From: Anastasia Toleva [REDACTED]
Sent: 29 January 2021 15:22
To: Maria Tomalova <Maria.Tomalova@arun.gov.uk>
Subject: RE: AL/2/21/DOC Tyrone House

Subject: FW: AL/2/21/DOC Tyrone House

'The supporting statement includes plan demonstrating a car parking for the proposed dwelling; however this has not been scaled. The proposed plan demonstrates 4 parking spaces, 2 within the proposed garage and 2 on the driveway. At planning stage, the proposed garage did not meet the requirements for a double garage. It is not clear if the internal size of the garage has been enlarged to accord with the current WSCC standards for double garage (6x 6m). Nevertheless, the site appears of sufficient size to accommodate the required onsite parking provision of 3 spaces. The details submitted would be considered adequate to meet the requirement of condition 7.'

FIGURE 1 - PROPOSED PARKING

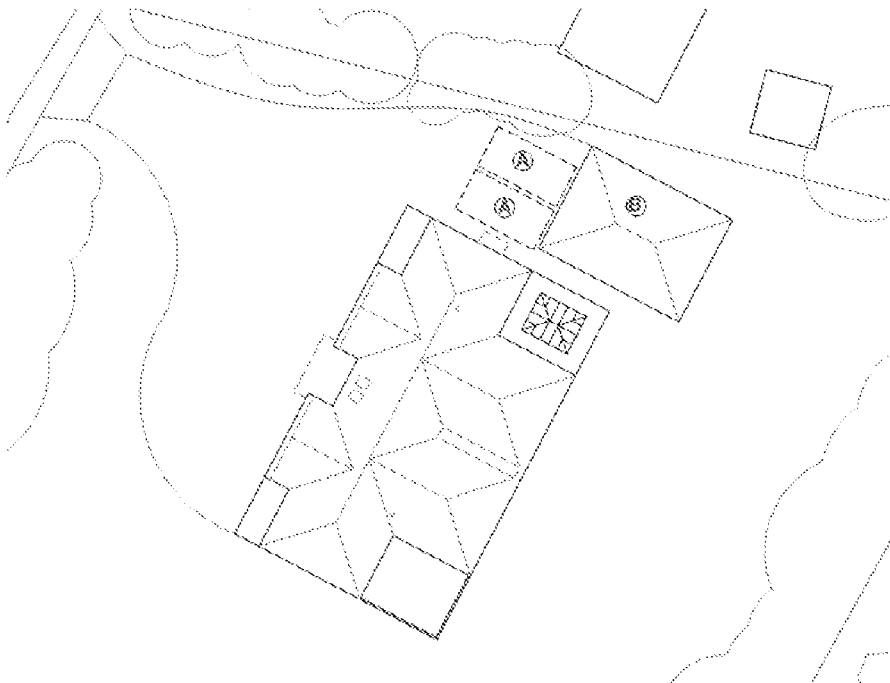
It looks generally OK, however if you can provide scaled plan it would be beneficial.

The garage does comply with the requirements of 6 x 6 m for a double garage as shown on the attached plan.

The garage is 6 x 6m internally – permitted drawing with dimensions added attached.
